6 February 2024

RE: 28 DAY NOTICE PRIOR APPROVAL APPLICATION FOR PROPOSED AGRICULTURAL BUILDING AT WEST LAND OFF SANDHILL ROAD, STEEPLE CLAYDON, BUCKINGHAM, MK18 2EN

TITLE
AG BUILDING
PLAN AND ELEVATIONS

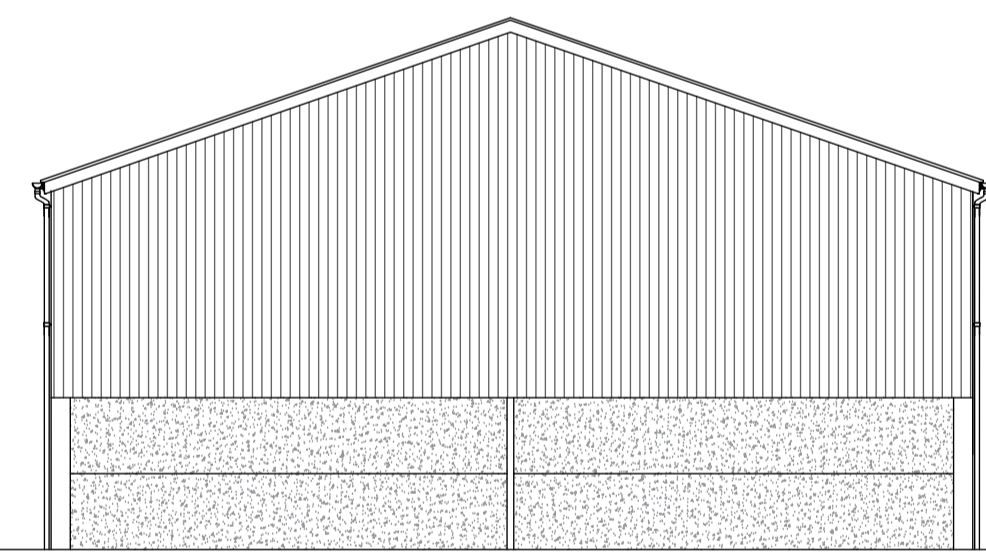
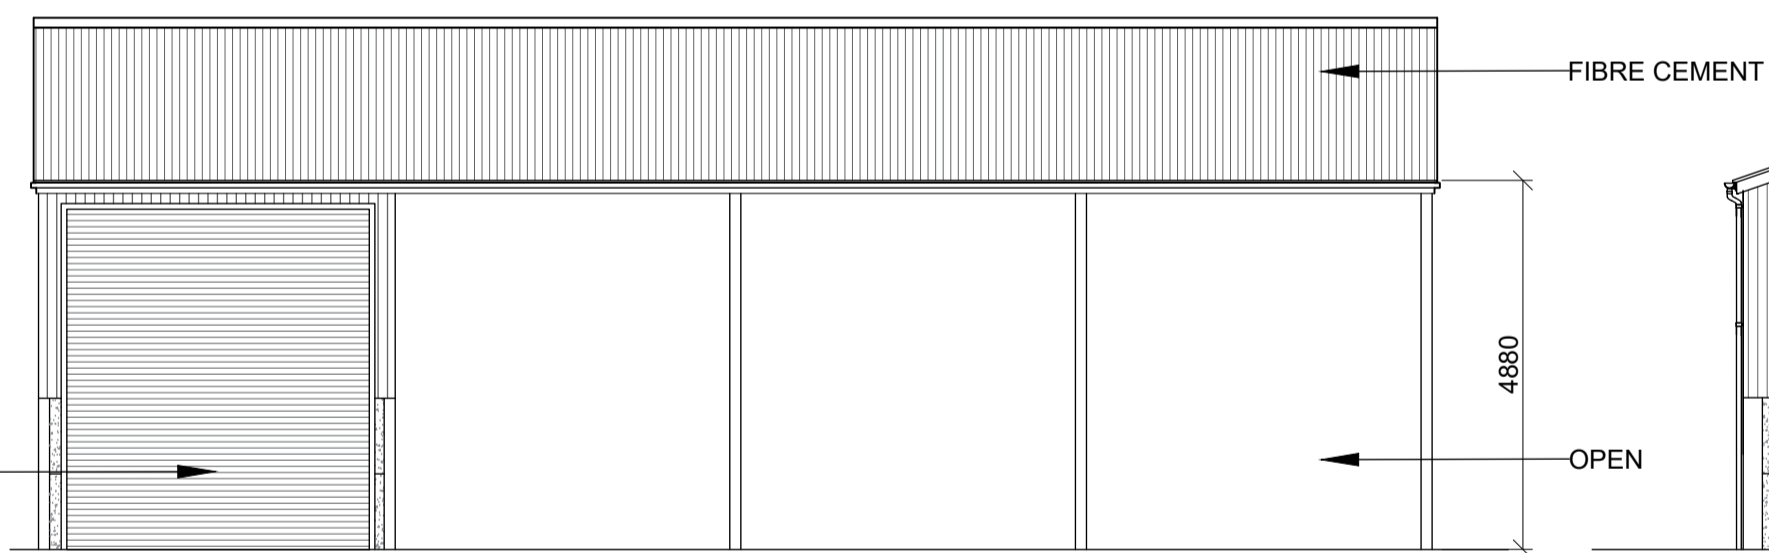
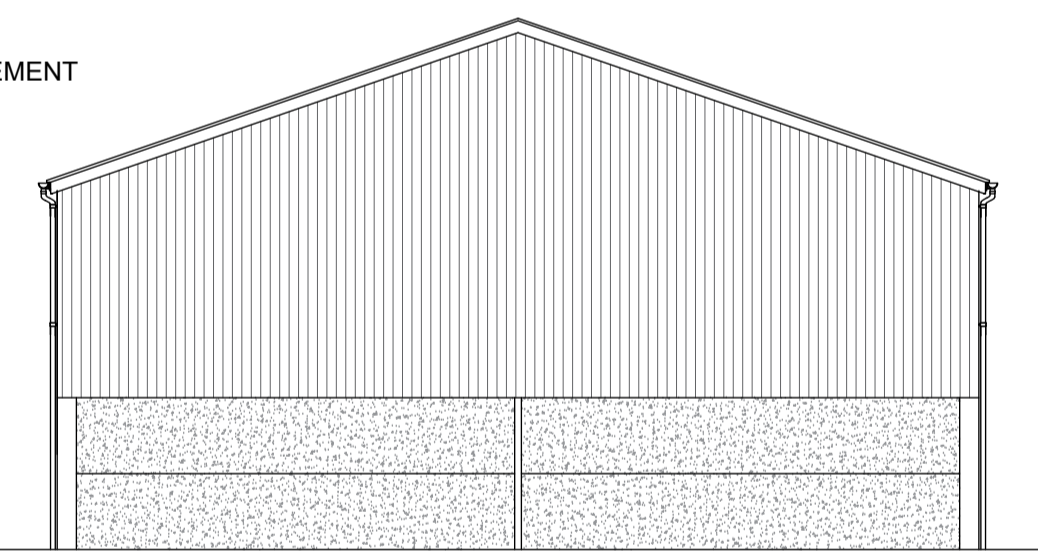
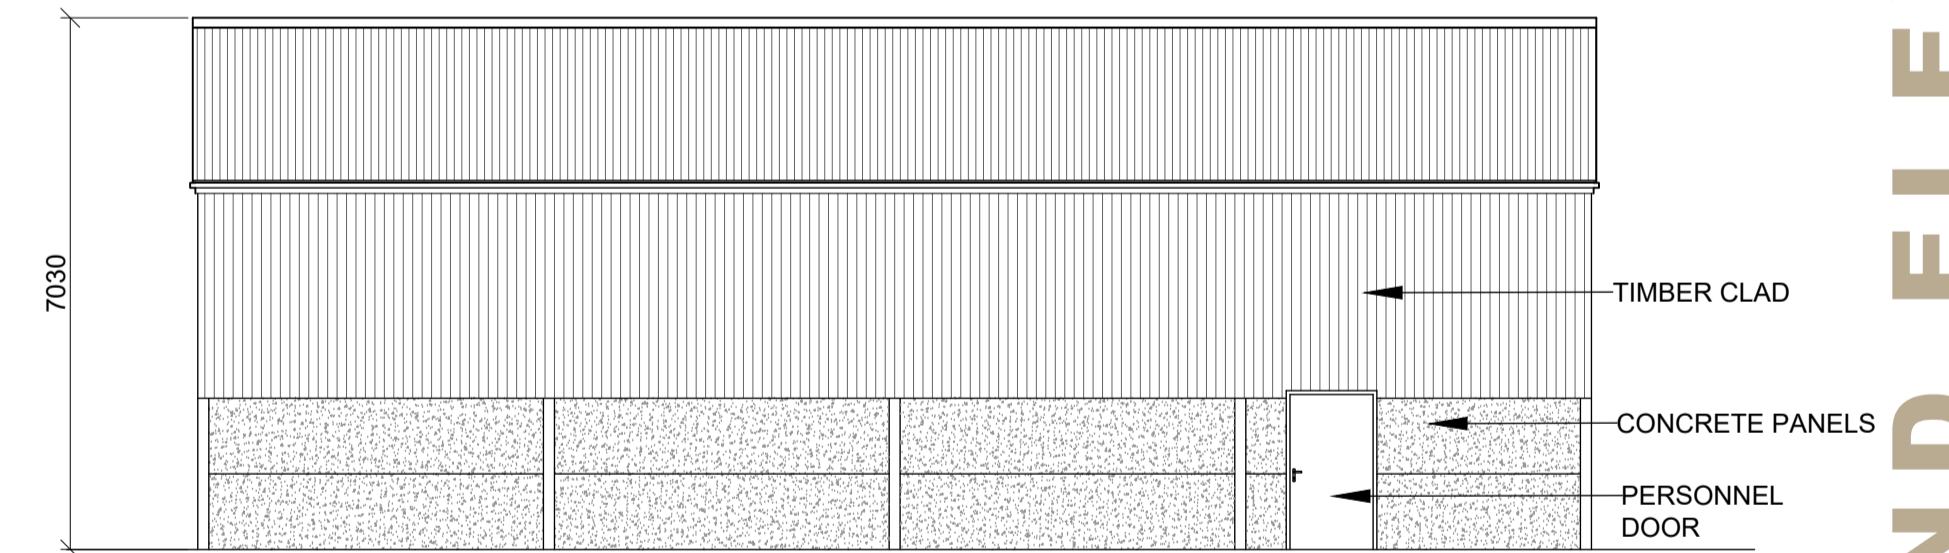
It is therefore proposed to enclose 3 sides of the barn with timber cladding, and provide a personnel door for access to the rear of the enclosed bay. Three of the bays would remain open fronted.

The building will be on the same site and be of the same size as that already permitted, the only changes being the addition of cladding and a personnel door to protect against the weather.
